26 October 2021

NSW DEPARTMENT OF PLANNING, INDUSTRY &
ENVIRONMENT
PO Box 1226
NEWCASTLE NSW 2300

Subject: Newstan Mine Extension Project (SSD-10333)
100 Miller Road, Fassifern, NSW 2283

Predicted subsidence contours

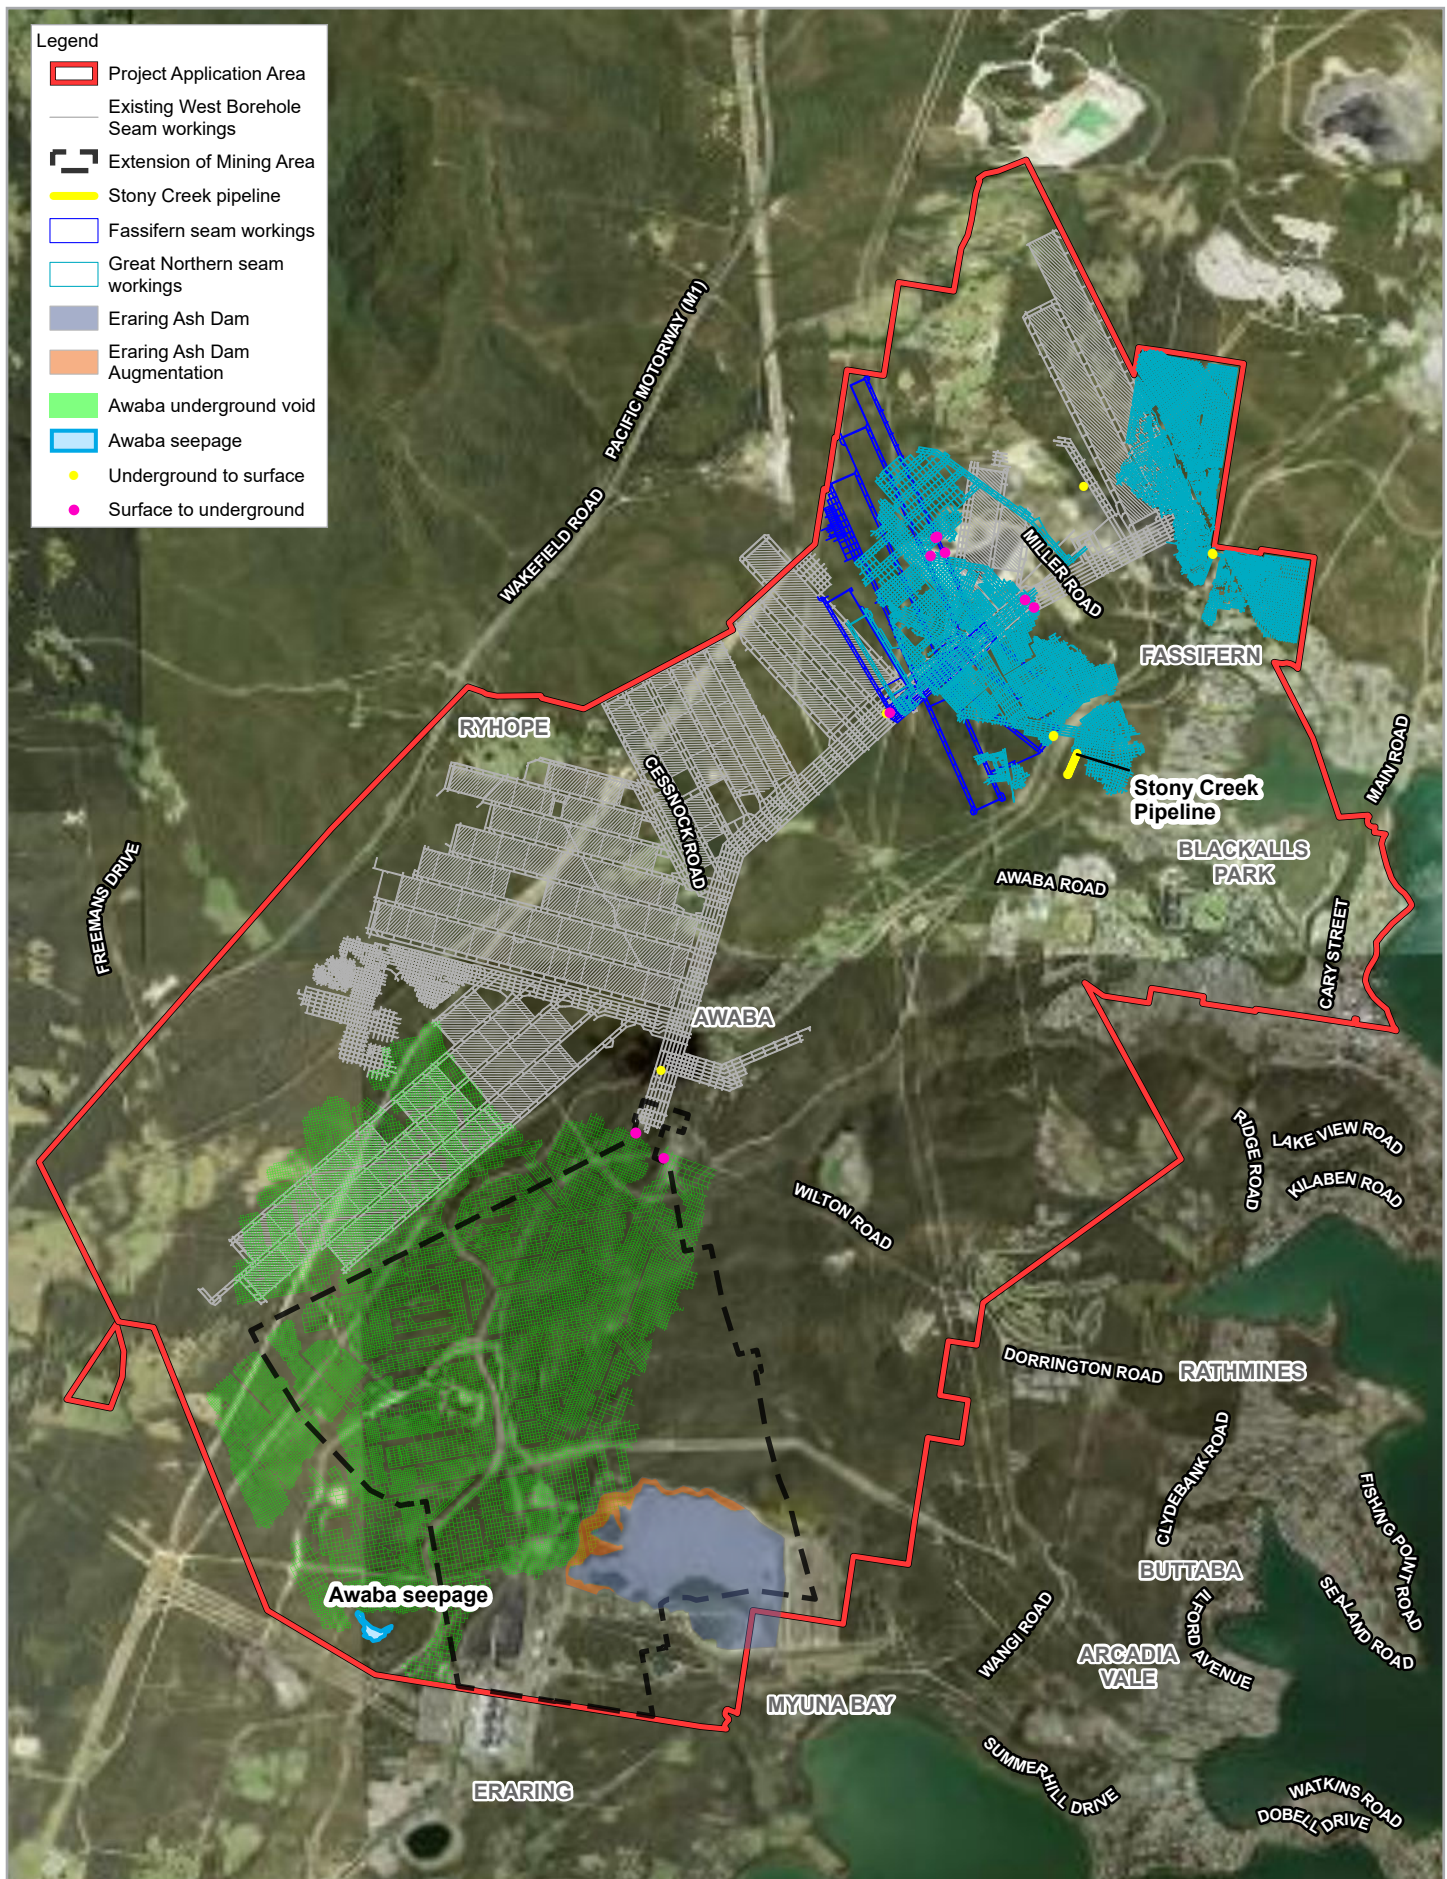
Concerns are raised on the long-term effects of the predicted level of subsidence on ecology, hydrology and future recreational use of the area. The proponents are requested to consider an alternate mine design which has a reduced extent of partial and full extraction area (especially in the Teralba Conglomerate spanning area) to minimise subsidence impacts.

The proposal does not address the impacts on the proposed Awaba Conservation Area which is identified as a significant biodiversity value area in Lake Macquarie Local Strategic Planning Statement 2020. The EIS predicts extensive subsidence (up to 3,250mm in vertical extent) in the bushland areas south-west of the Awaba township. Mining activities should be undertaken in a way that avoids and minimises impacts and respects this intended future use.

The proposal involves mining activity directly beneath the Eraring Ash Dam and predicts subsidence in the order of 800mm to the ash dam. Council staff have significant concerns over the potential for the proposed mining activity to cause ground movement in the ash dam structure, which is already known to be geotechnically unstable, and result in fracturing that will create flow paths for ash contaminated water to flow. Given the very risk associated with mining in this area, Council staff do not believe the project has adequately demonstrated adherence to the precautionary principle in either its method or assessment or the design of the mine plan in this area.

Figure 3-2 Awaba Colliery Surface Site components plan

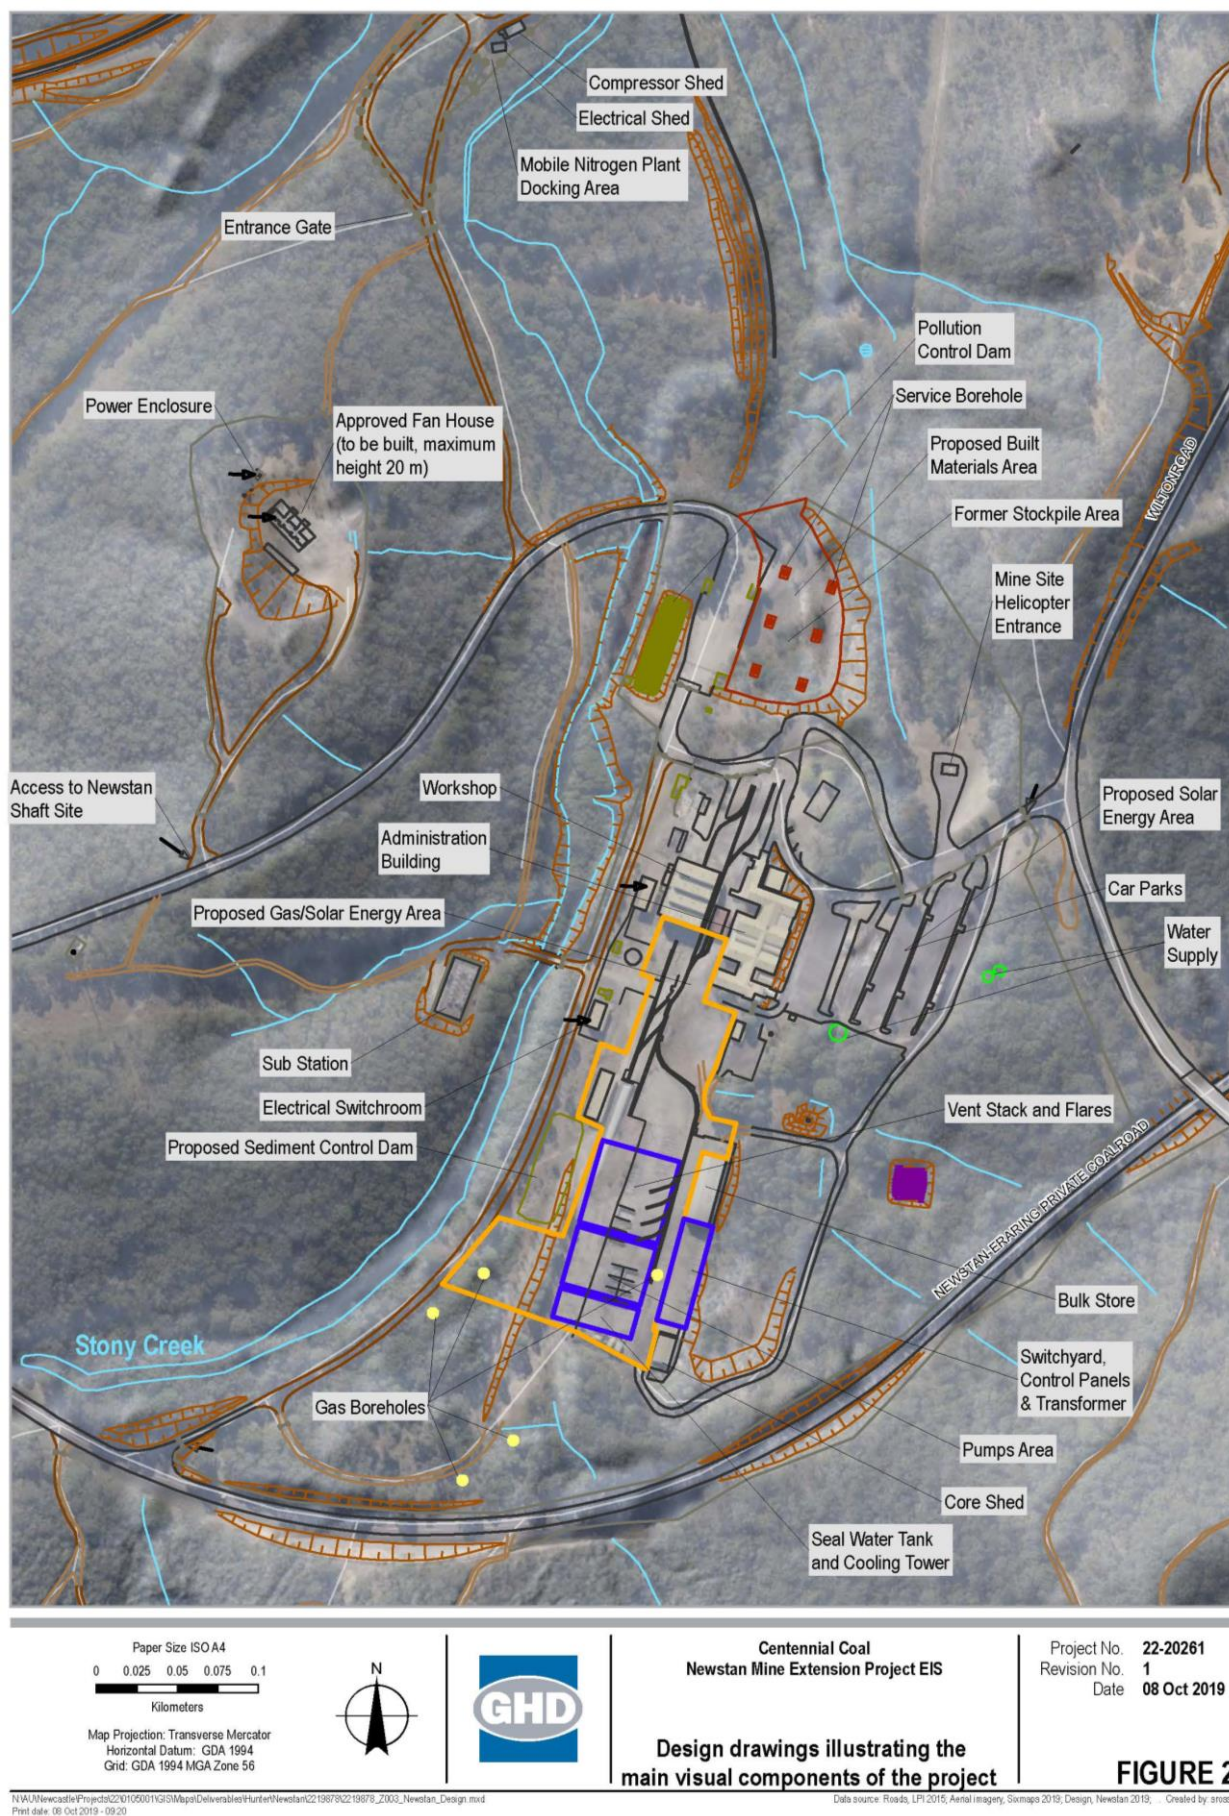
Council supports the findings of the Visual Impact Assessment. It is noted the colour of the fan house is not identified in the document. Given this is the only built element that will have some level of exposure, it is recommended that a visually recessive colour, such as charcoal grey or black is imposed as a condition of consent if a favourable determination is made on this application.
